Application no: H21/1059/99

Description: Erection of a rear first floor
and ground floor extension

Location: The Old Rectory
Rectory Road
Tydd St Mary
Lincs

NOTICE OF ACCEPTANCE OF AMENDMENT

DRAWING NO: 75/99/2 - A

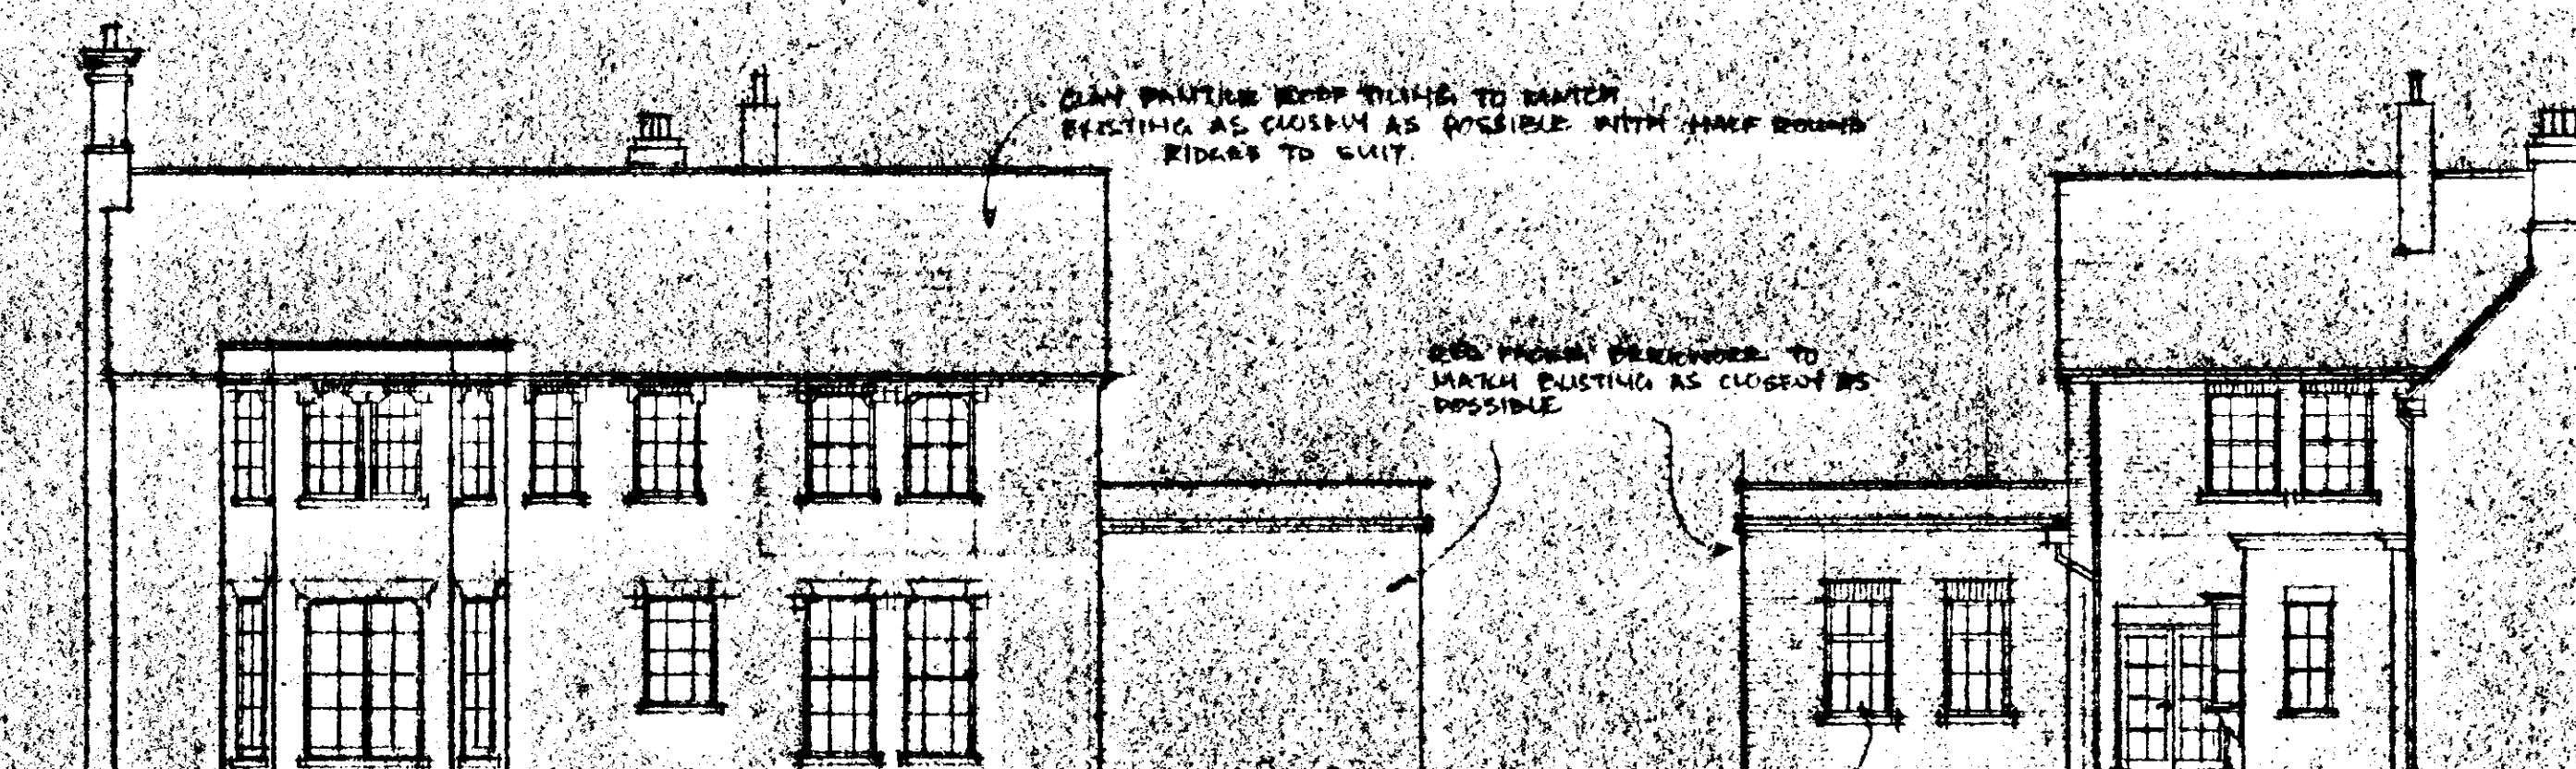
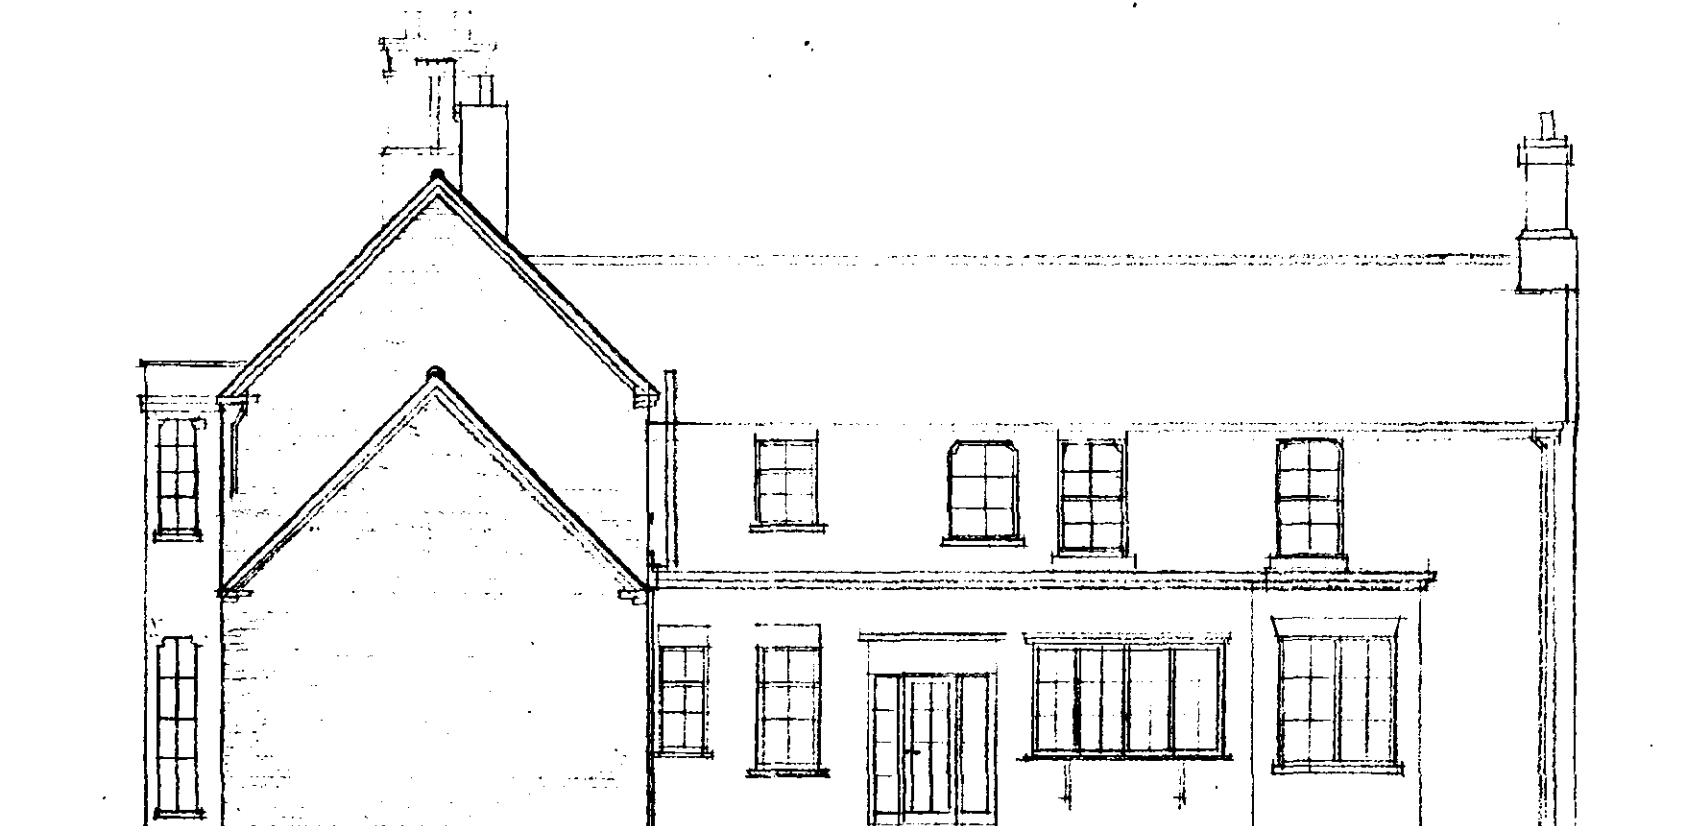
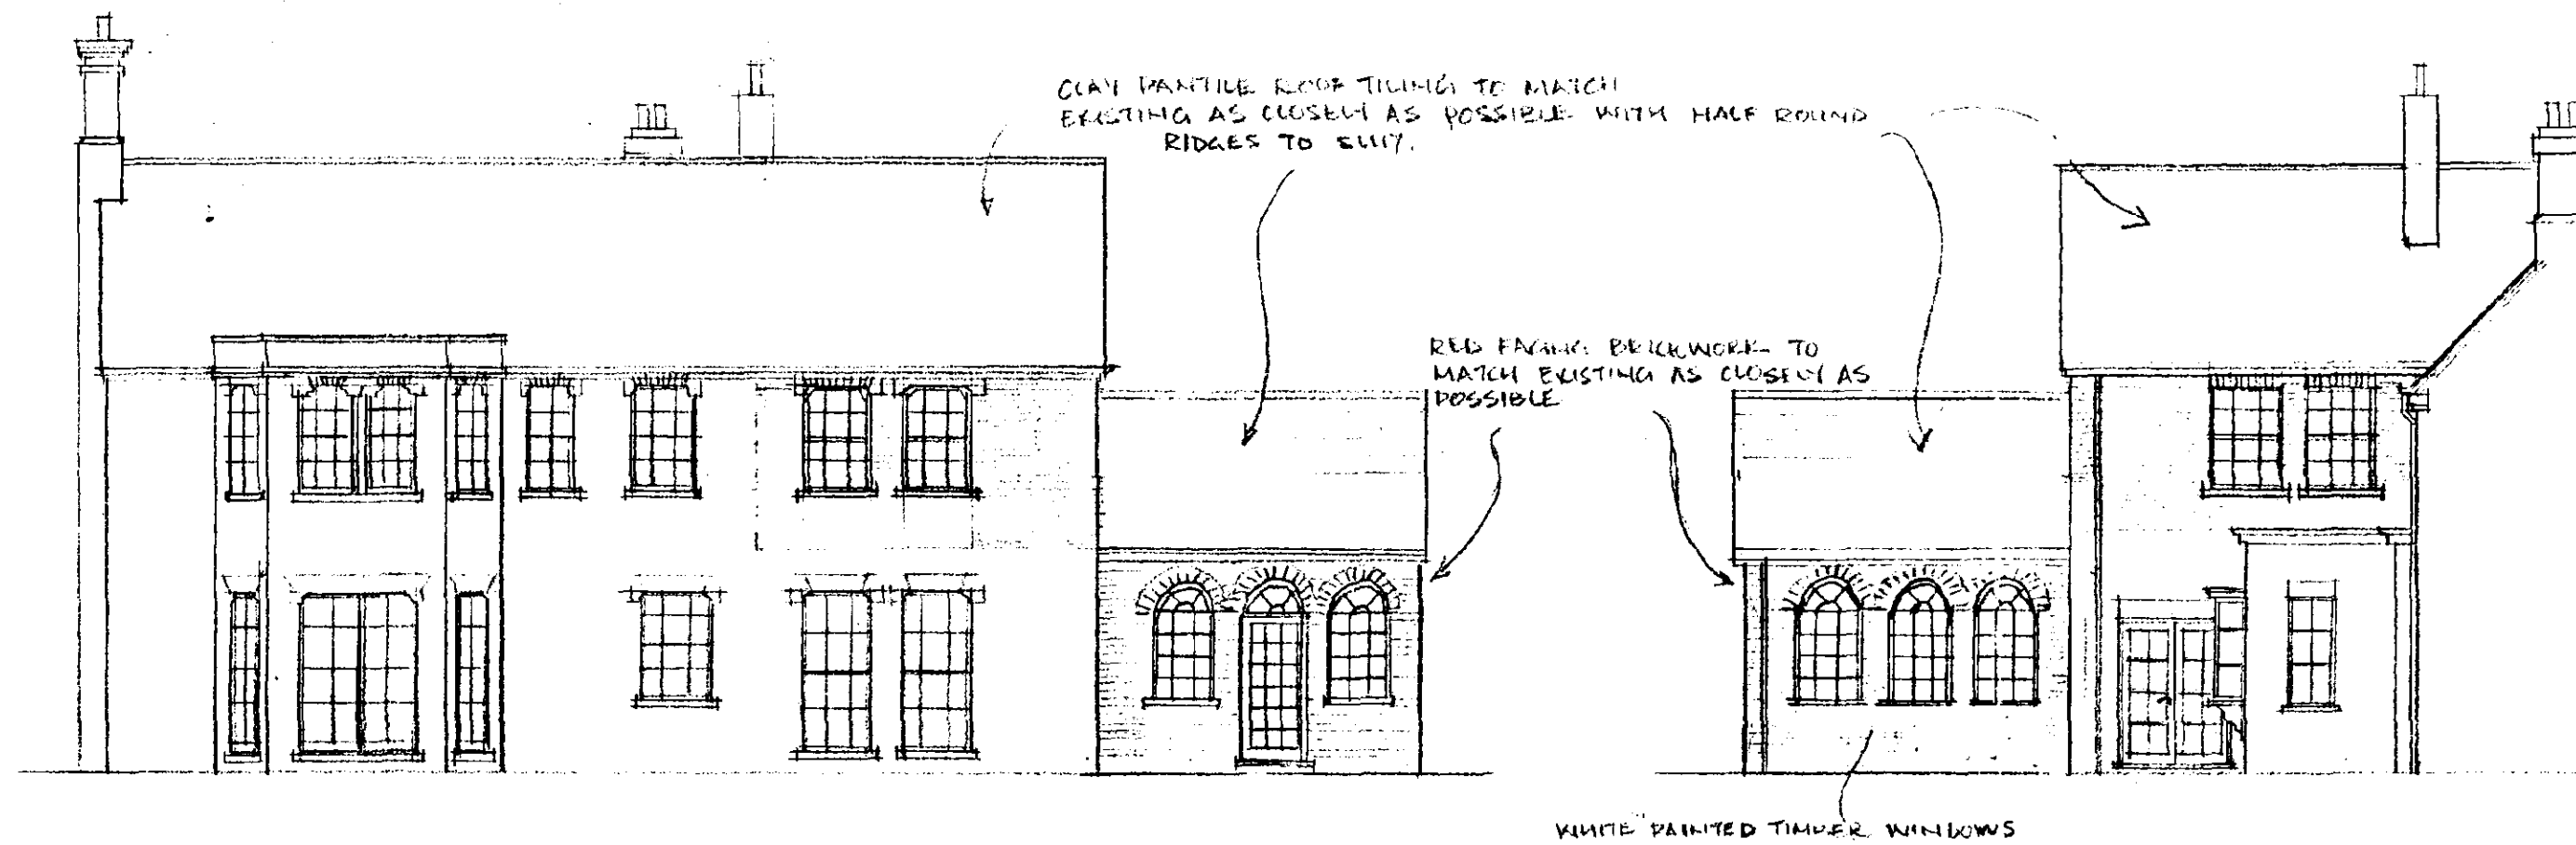
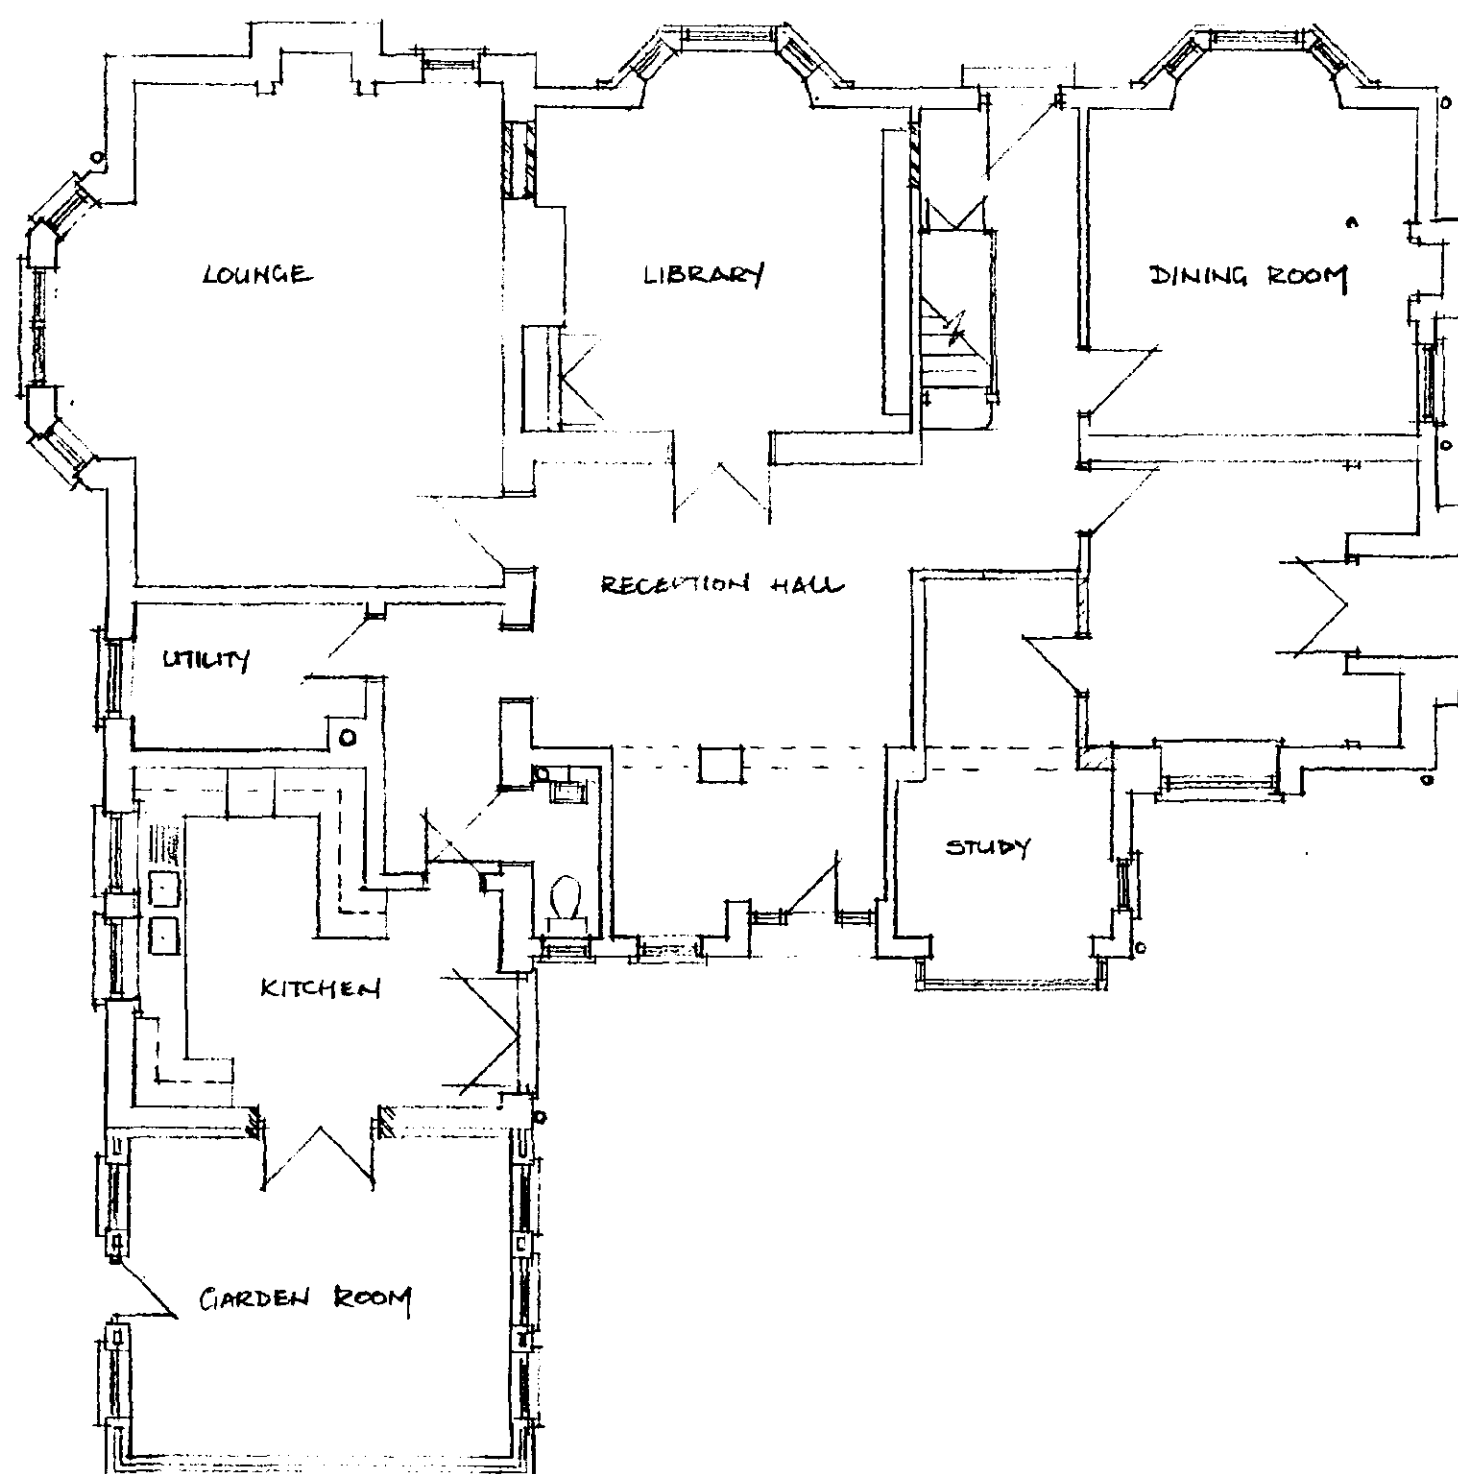
Amendment: Replace parapet/flat roof with a pitched roof
Dwg. No. 75/99/2-A

REPLACE PARAPET
FLAT ROOF WITH A
PITCHED ROOF.
